REPORT UPDATE

Application No: BE/73/14/PL

LOCATION: Land at Oldlands Farm
Shripney Road
Bognor Regis

PROPOSAL: Erection of 2 No. detached industrial/distribution units (B1(c)/B2/B8) including access & servicing arrangements, car parking, landscaping & associated flood compensation area. This application is a departure from the development plan. This application also lies within the parish of Aldingbourne

For planting details refer to Management Plan: DLA.1606.RPT.MAN.01 Rev E
Refer to drawing L02-02 Rev L for Hard Landscape Layout

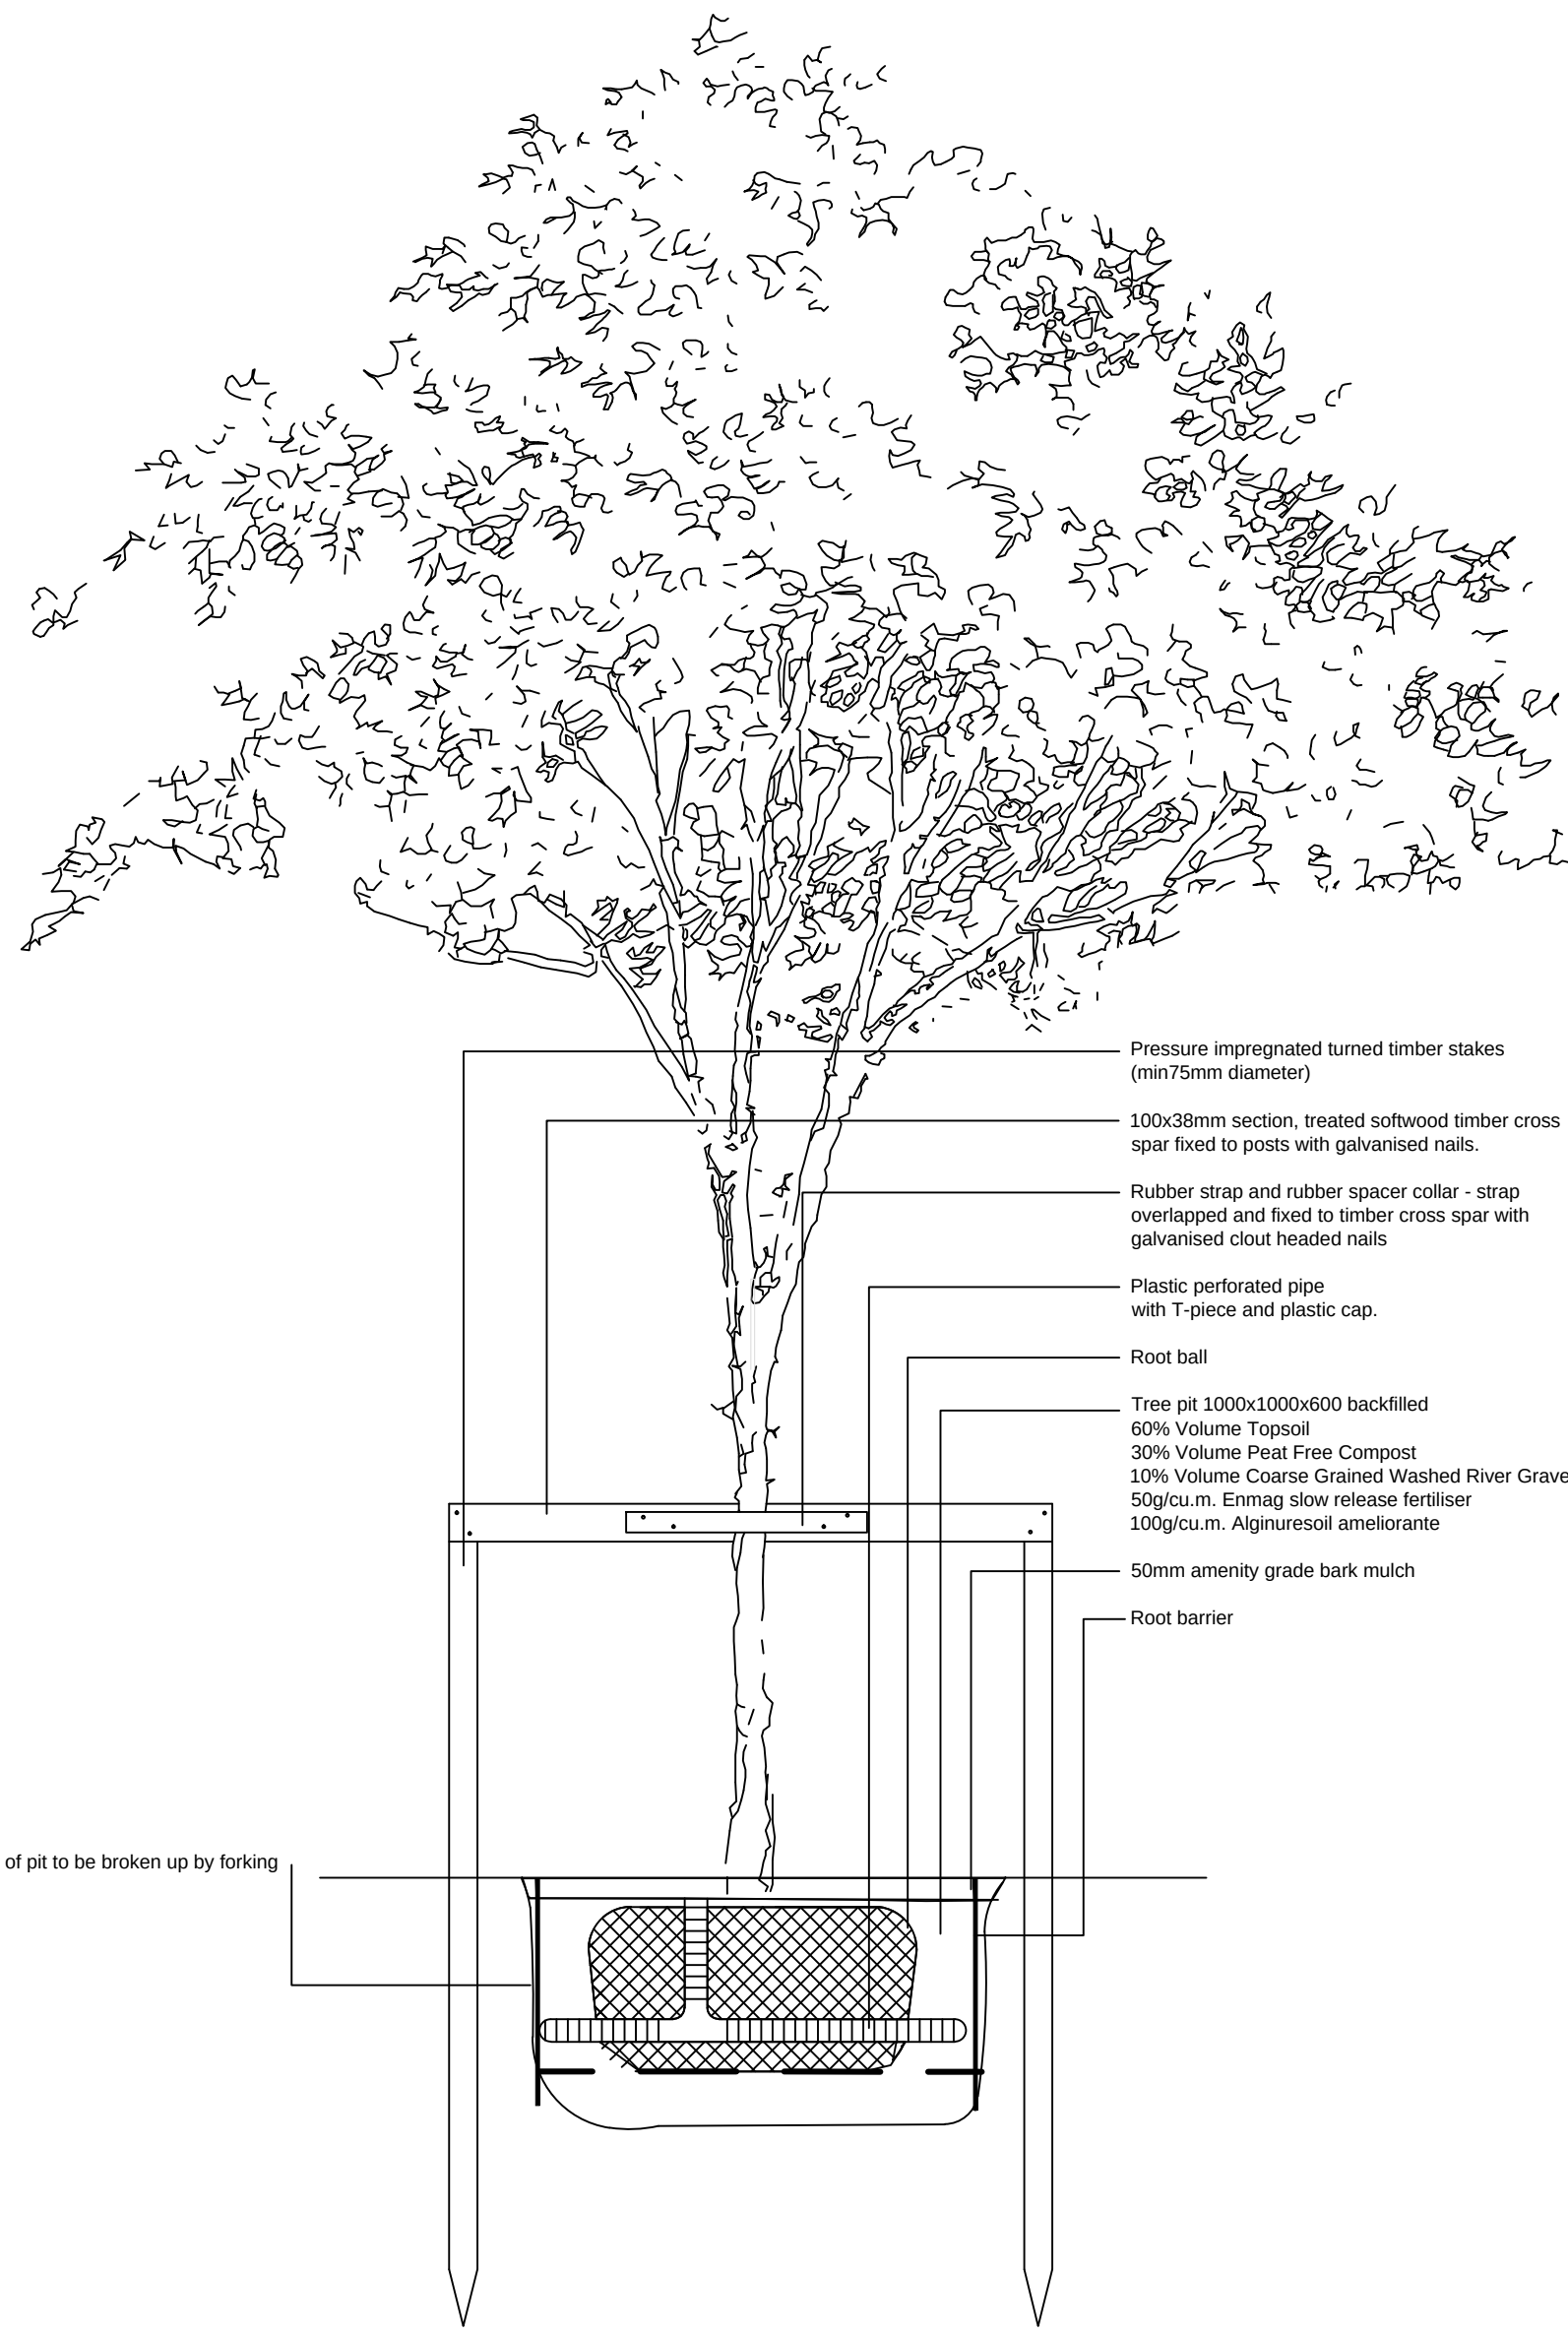
Trees & Landscape Officer - There is limited landscaping / screening along the railway side of the proposal between the proposed planning at the north and the SUDS area. In addition there is no screening proposed to the north of Unit 2 - any screening in this area will help to reduce the scale of the building. Similarly there is no landscaping proposed around or integral to the car parking areas. In each of these cases further planting should be provided to allow for improved screening and setting for the development.

Committee will see that there is no such landscaping proposed within the car parking areas. Further, the Council's Trees & Landscape Officer has commented that there is no reason why landscaping cannot also be incorporated on the northern boundary (it does not have to be substantial trees to be of visual benefit). Therefore, it is proposed that recommended condition 19 be amended to require a landscape scheme to be agreed because the submitted scheme remains unacceptable. The condition would therefore read;

comments (see above). Additional landscaping is now proposed along the eastern boundary, additional tree planting incorporated in front of unit 2 on the north western boundary and additional landscaping has been incorporated.

No development shall take place until there has been submitted to, and approved by, the Local Planning Authority, a landscaping scheme including details of hard and soft landscaping and details of existing trees and hedgerows to be retained, together with measures for their protection during the course of the development. The approved details of the landscaping shall be carried out in the first planting and seeding season, following the occupation of the buildings or the completion of the development, whichever is the sooner, and any trees or plants which, within a period of five years from the completion of development, die, are removed or become seriously damaged or diseased, shall be replaced in the next planting season with others of similar size and species, unless the Local Planning Authority gives written consent to any variation.
